Renovation of existing stables & office/workshop to create a two bedroom Annexe ancillary to main dwelling & replace existing flat roof with pitched roof incorporating 8 No. rooflights.

West Kingston Barn Kingston Lane Kingston

Thank you for your internet comments made on 7th March 2018 which has been recorded as '**no objection**' with the comments as follows:

Site Block Plan (1:500)

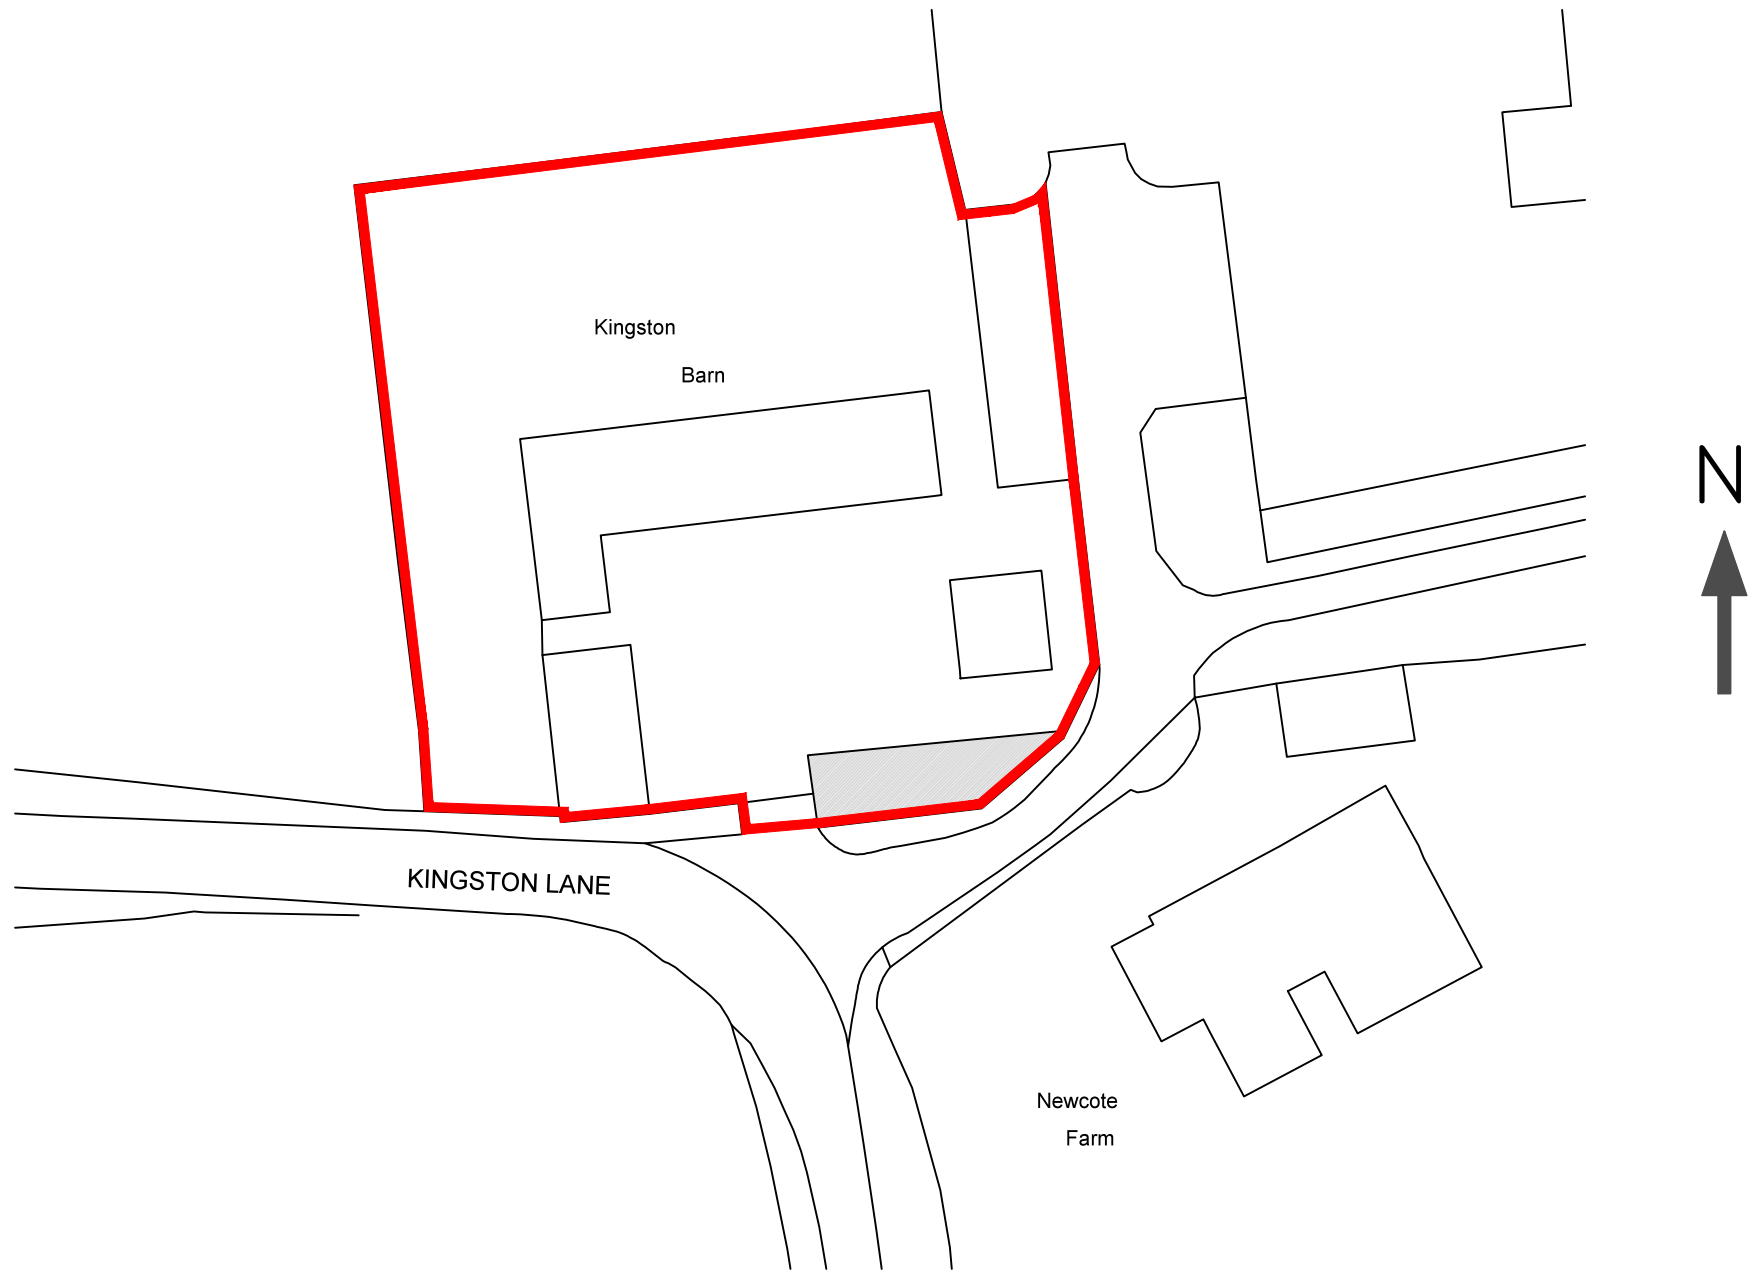
- Is there sufficient, adequate and safe onsite parking (given that the access to Kingston Lane is on a sharp bend)*
- There should be a condition that the accommodation will be occupied solely for purposes ancillary to the occupation of the existing dwelling and will not be used as a separate unit of accommodation. There is particular concern about this because it appears that an existing Annexe (possibly approved under K/15/97) has been advertised for holiday let and this matter will be raised with the Arun Compliance Officer.*
